City of Albuquerque Stormwater Construction Site Inspection Report

ESC File No.	K09E048B	Project Name:	Dutch Brothers		
NPDES Id. No.	NMRI005FQ	Location:	210 98th St NE		
8/30/2023	Owner		Contractor		
Operator	Heritage Trails Development, LLC				
Contact name & title	John Caglia				
e-mail	john.caglia@dutchbros.com				
Contact Phone #	714-883-9092				
COA Inspector	Chancellor English		Start/End Time:	1030am	
Construction Phase:	infrastructure nearly complete				
Type of Inspection:	Regular	Storm Event	Post Storm Event >0.25"	311/Complaint	Follow Up
Weather at time of inspection?	Clear		Temperature: ~	85	
Estimated date of last storm 0.25" or greater	8/8/2023

Title: EROSION AND SEDIMENT CONTROL PLAN
220 98TH STREET NW
ALBUQUERQUE, NM 87121

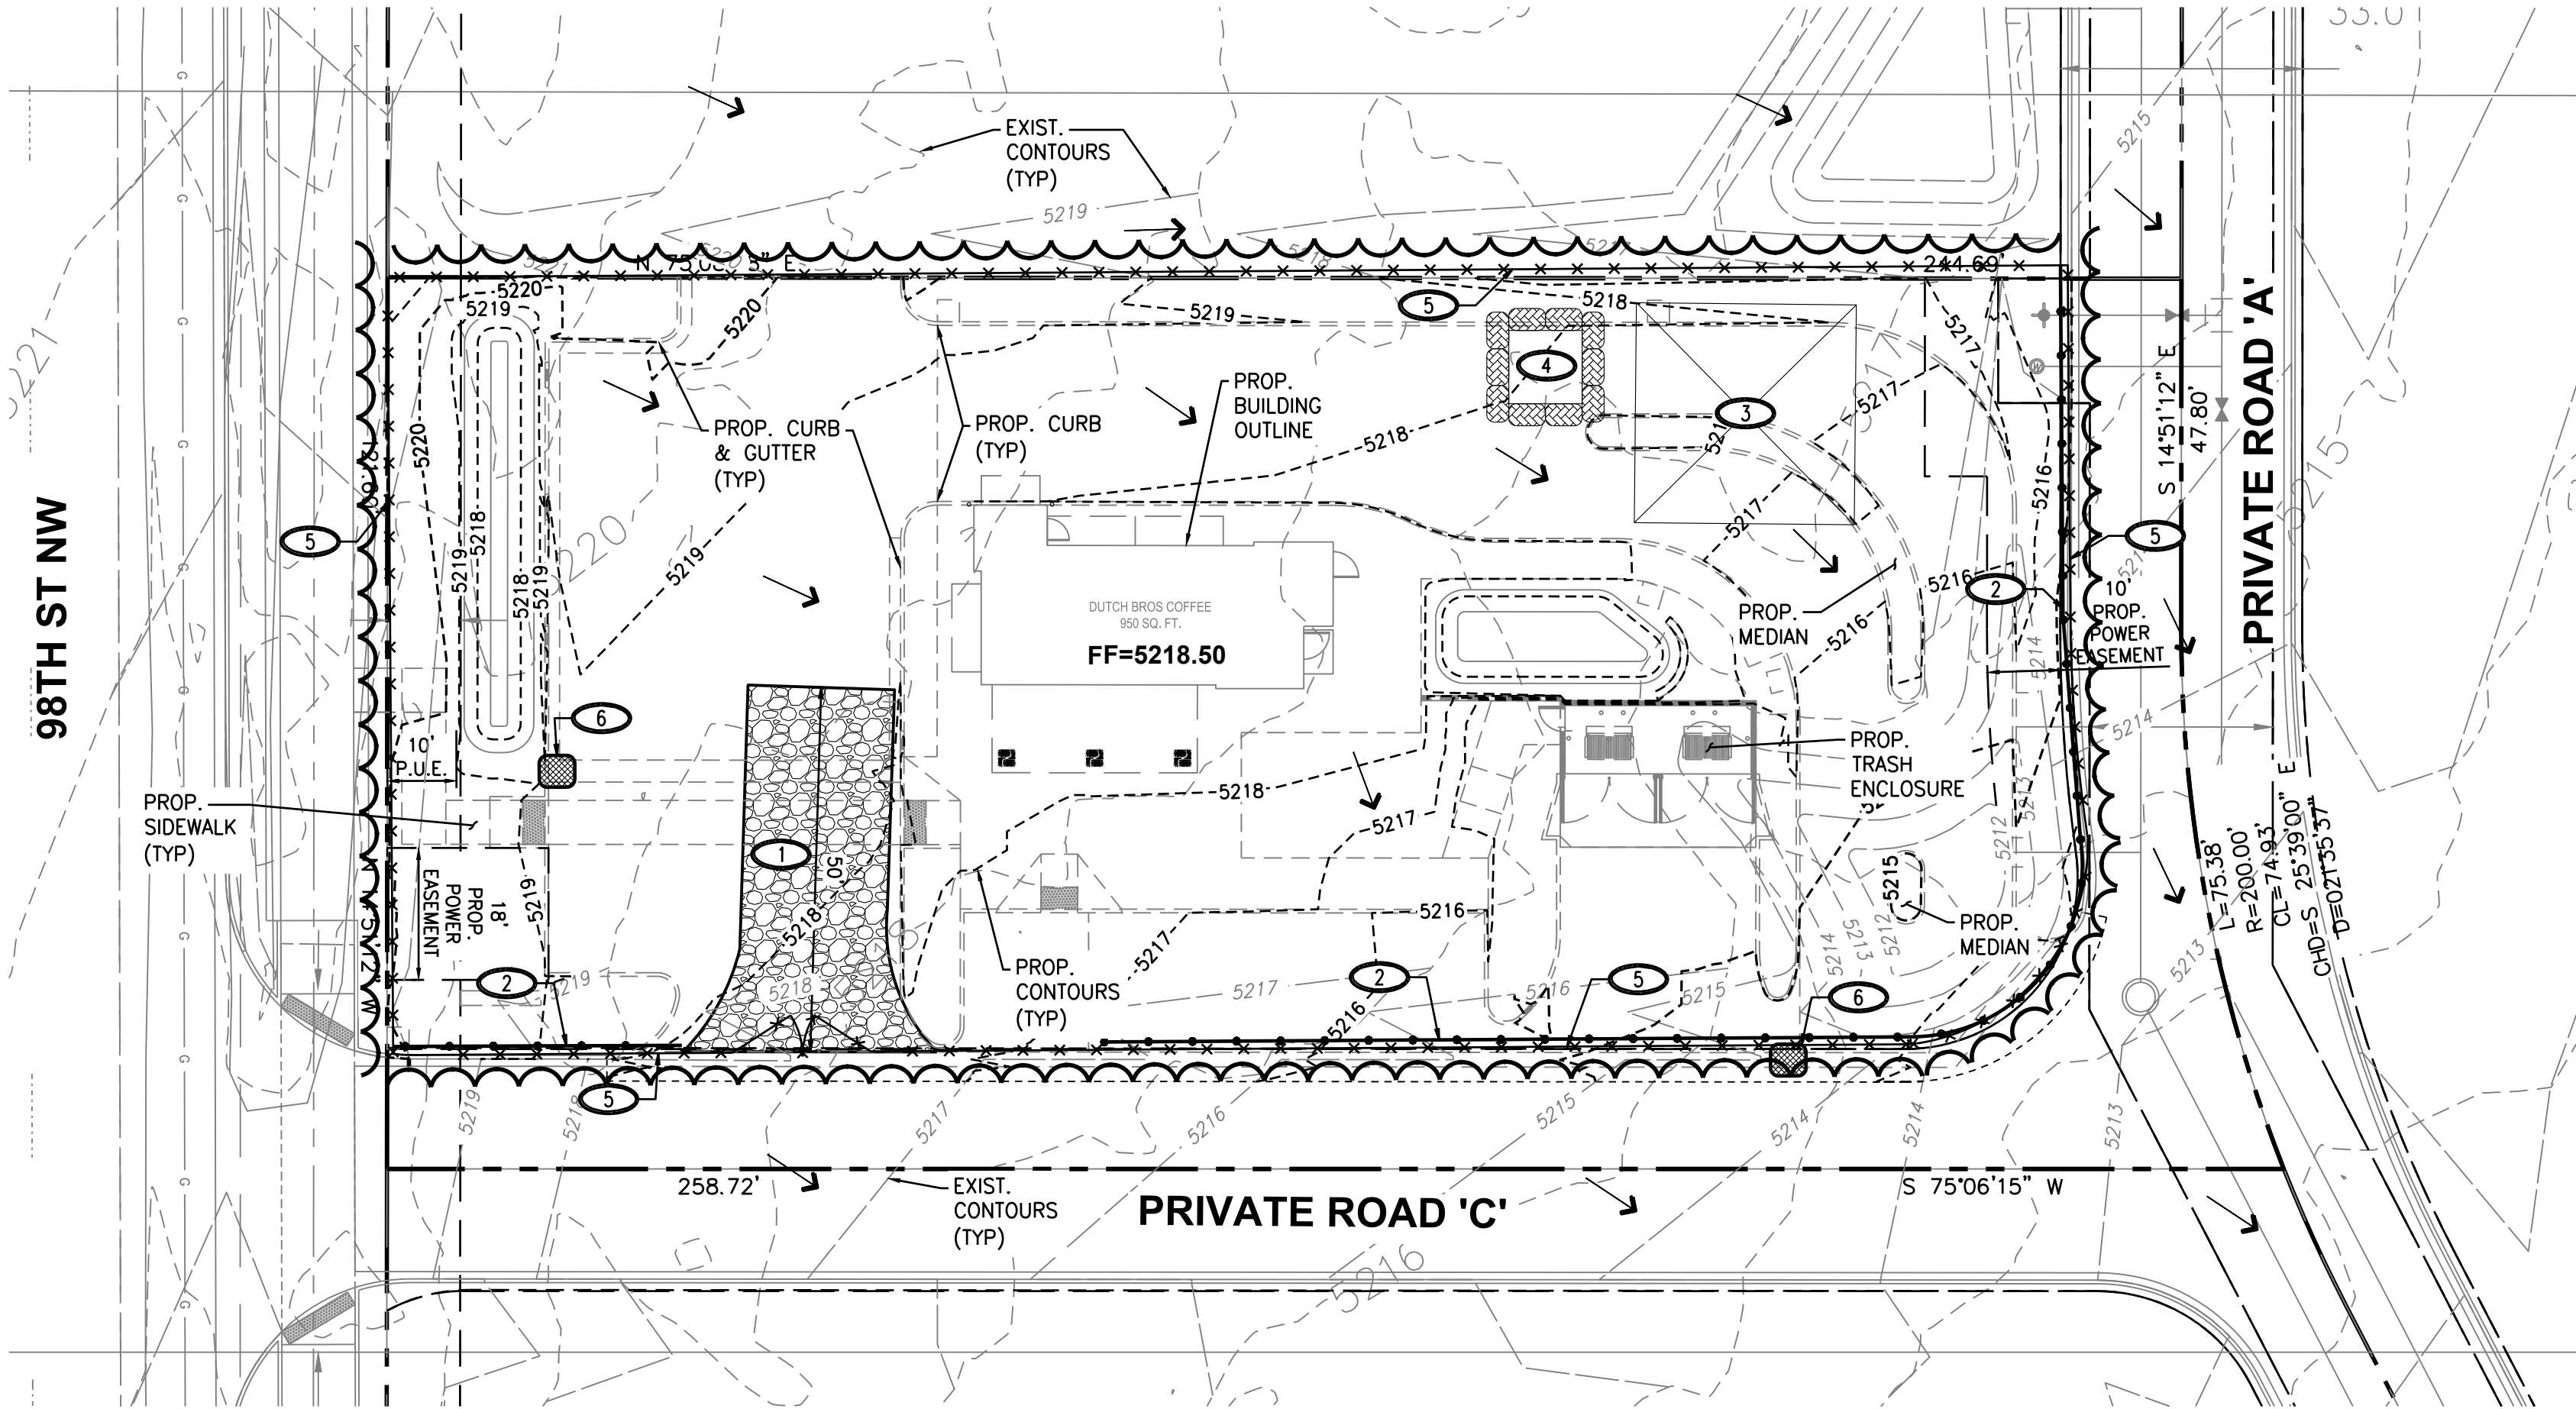
Item Number	Deficiency/ Corrective Action				
1	The permit coverage posting was missing in violation of CGP Part 1.5. Required mitigation: You must post a sign or other notice of your permit coverage at a safe, publicly accessible location in close proximity to the construction site per CGP Part 1.5.				
2	The SWPPP and inspection reports were unavailable for the inspection in violation of CGP Parts 4.7.3 and 7.3. Construction equipment stored and land disturbance off-site that is not marked on the ESC Plan map submitted to the city in violation of CGP Part 7.2.4. Required mitigation: You must keep a current copy of your SWPPP and all inspection reports at the site or at an easily accessible location so that it can be made available at the time of an on-site inspection per CGP Parts 4.7.3 and 7.3. The site map must include locations of on-site and off-site construction support activities per CGP Part 7.2.4.b.vii.

3	The are multiple gaps in the perimeter silt fence in violation of CGP Parts 2.1.2 and 2.1.4. Required mitigation: You must design and install all stormwater controls in accordance with good engineering practices, including applicable design specifications per CGP Part 2.1.2. You must ensure all stormwater controls are maintained and remain in effective operating condition during permit coverage and are protected from activities that would reduce their effectiveness.
